**Date:** 11 April 2024  
**Our ref:** 66350/01/MLW/AG/31428655v1

## **Planning application ref. 24/00539/F: Land East of Stratfield Brake and West of Oxford Parkway Railway Station, Oxford Road, Kidlington**

Figure 3.2: Allocated Sites

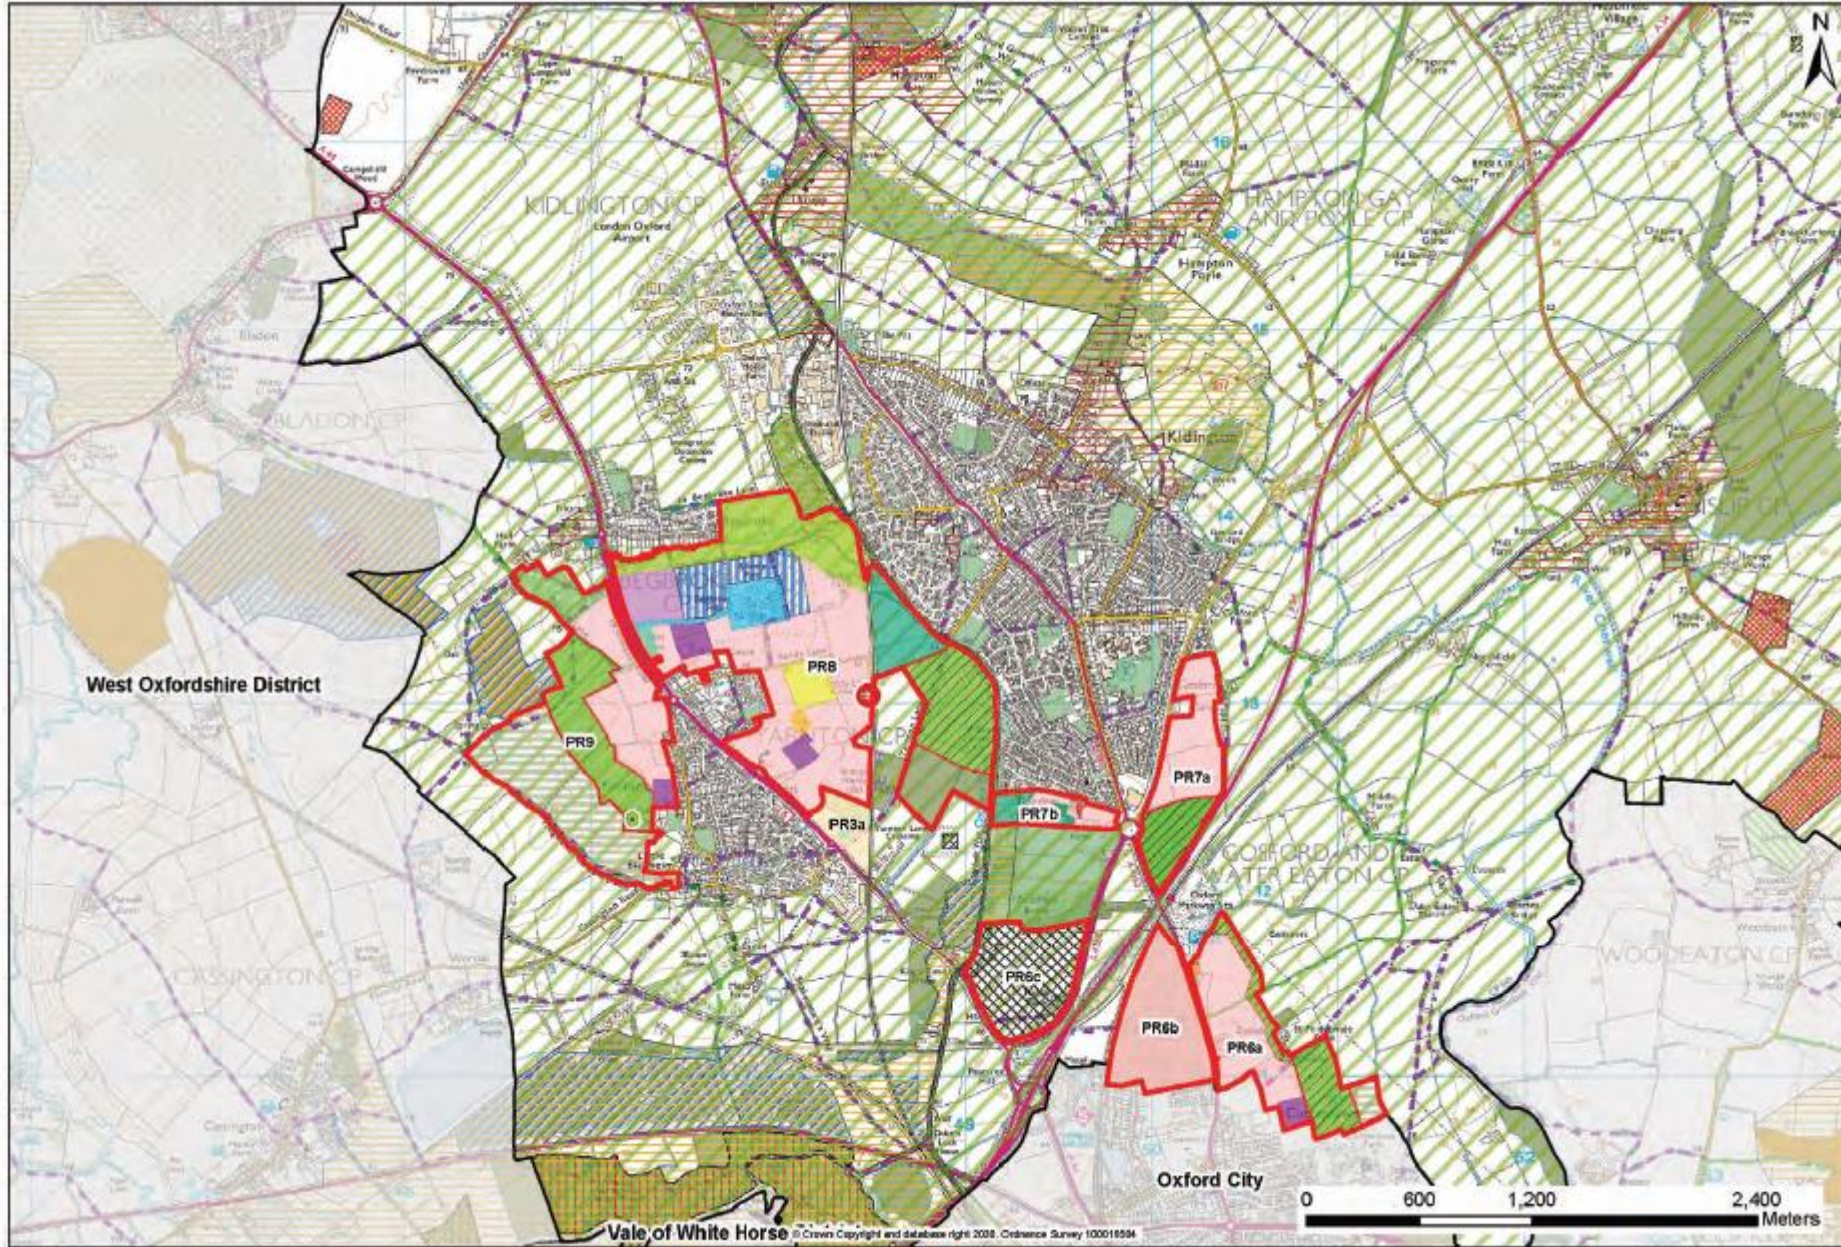
However, this letter draws attention to three key areas of concern: highways and transport, visual impact, and amenity impacts. We highlight that allocated site PR6b seems to have been omitted from the analysis and assessment provided in the stadium application. This forms a key oversight and must be rectified in order to provide a comprehensive assessment of impacts of the proposed development. Full detail on our concerns is provided in the body of this letter.

Whilst the stadium application seeks to encourage visitors to the site to travel via public transport/ foot/ bicycle as much as possible, there will remain an inevitable increase in the traffic volume and associated congestion on the local highways network. The stadium application should provide a cumulative assessment of the impact of the proposal on the highways network, accounting for the allocated sites including PR6b.
